# Consultee Comments for Planning Application 22/01785/PLF

Application Number: 22/01785/PLF

Proposal: Conversion of existing agricultural building to two dwellings

Name: . Building Conservation

PROPOSED ROOF PLAN

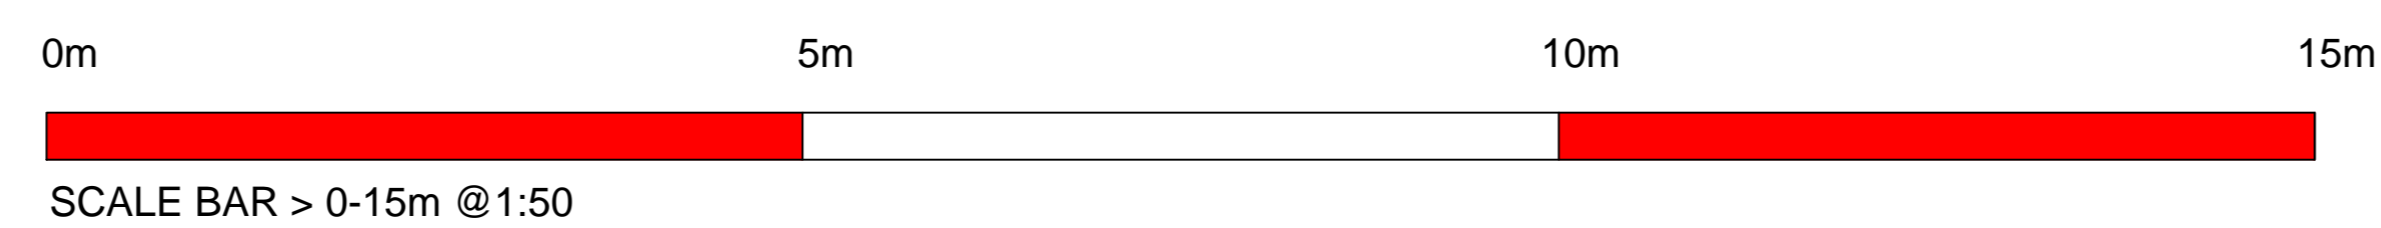
The areas of grouped rooflights have been removed and the rooflights are now all proposed to be the same size which would reduce the risk of loss of historic fabric and would reduce the harm caused by the appearance of a glazed wall.

PROPOSED EAST ELEVATION

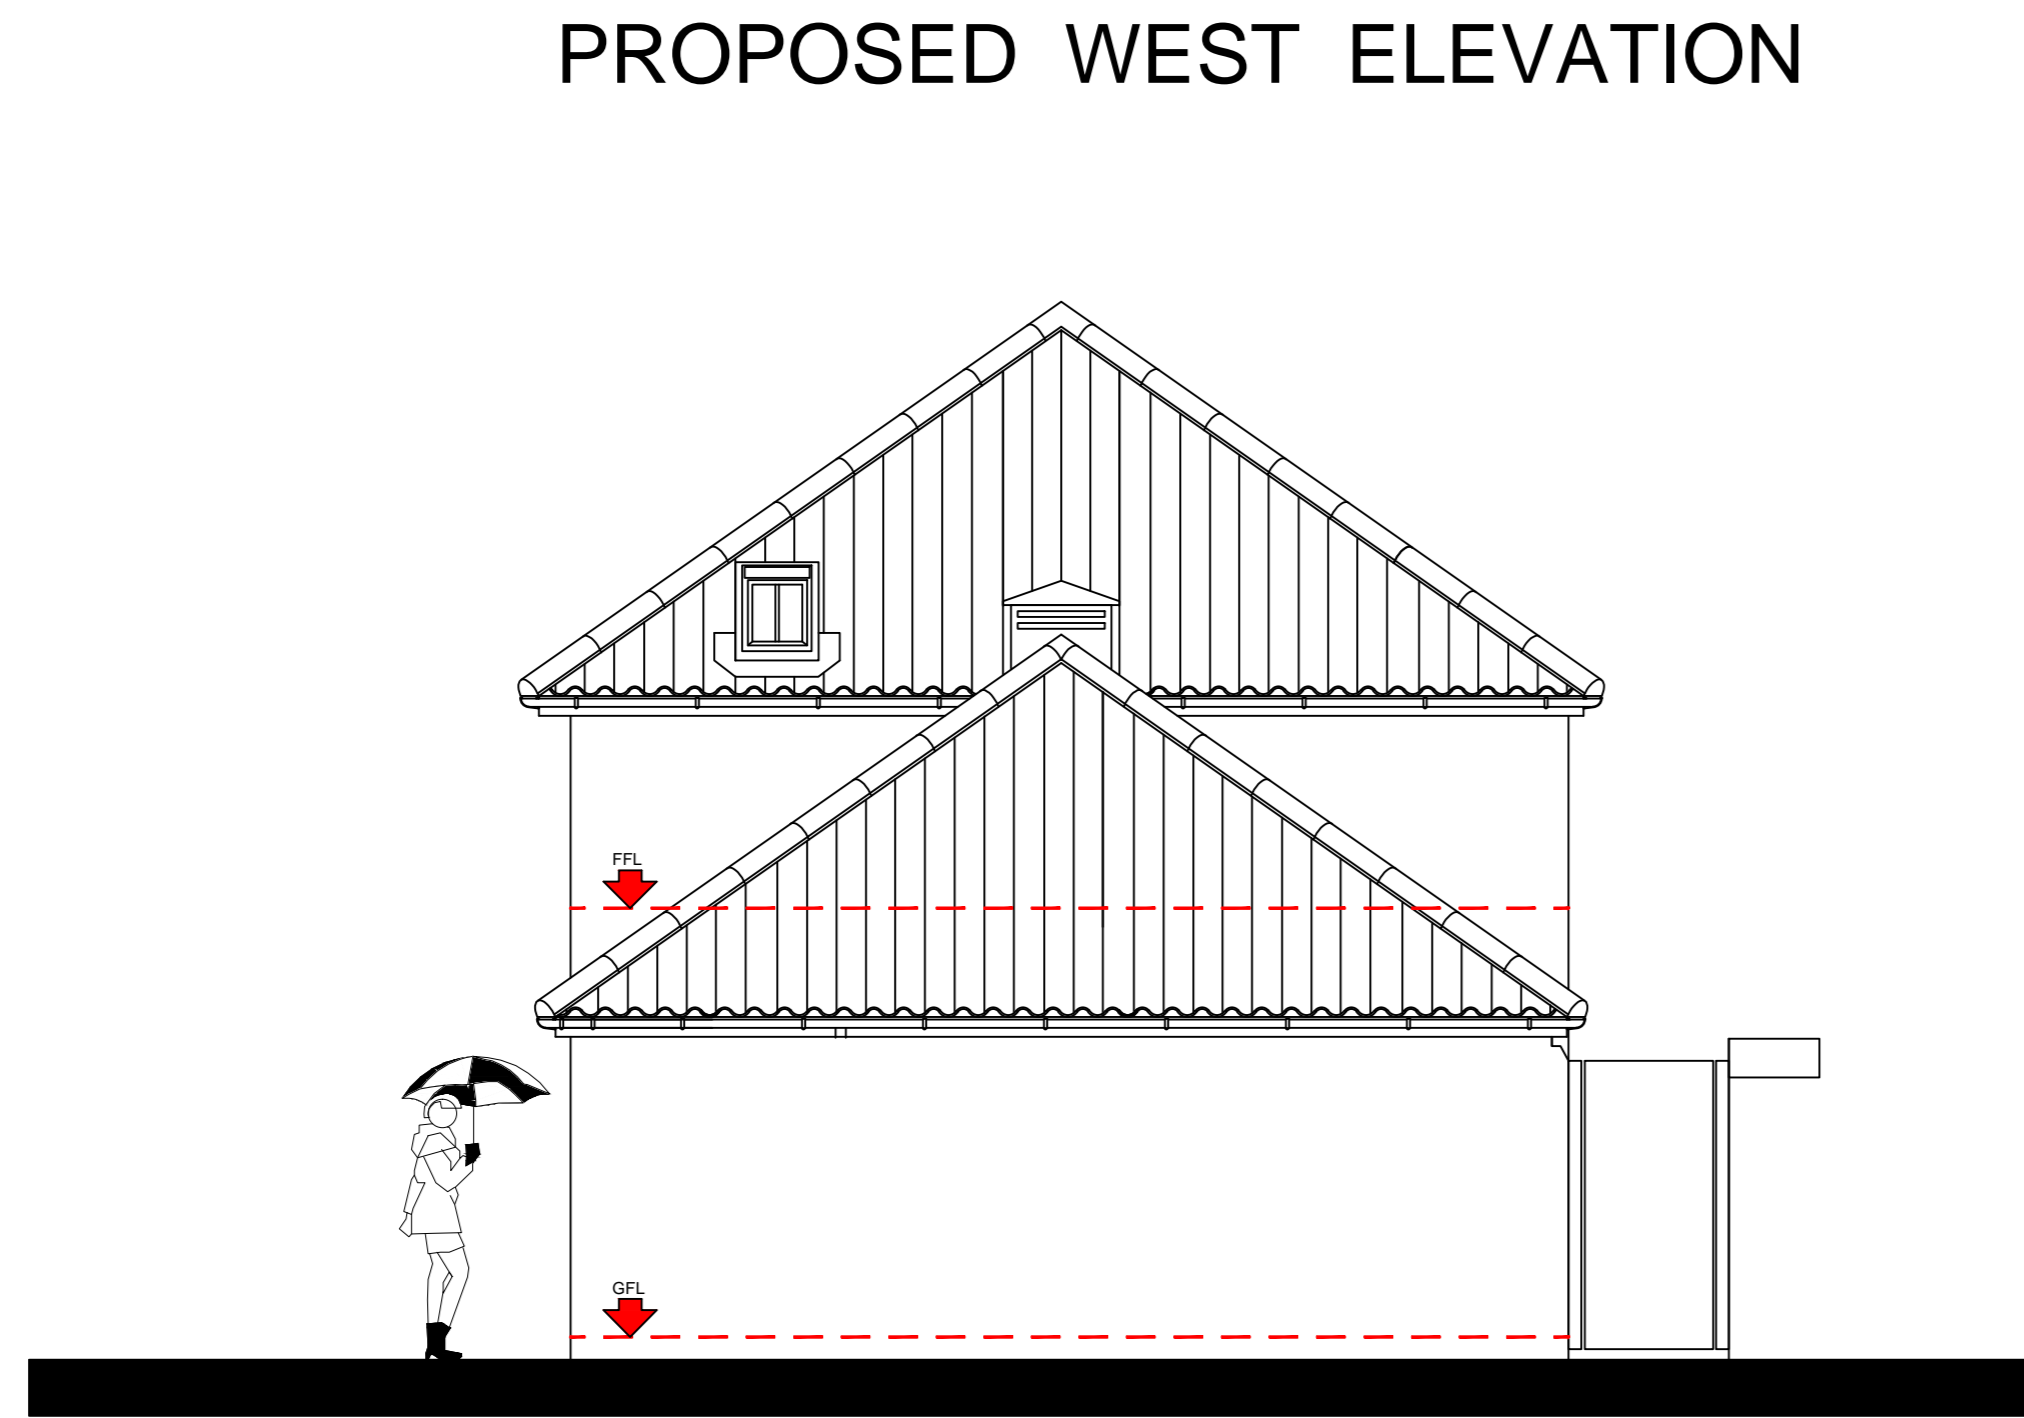
The no.2 windows above the glazed doors on the east elevation were recommended to have a sensitive break in between which has now been implemented. This element would reduce the harm caused by the appearance of a glazed wall and would be better in keeping with the architectural and historical significance of the property.
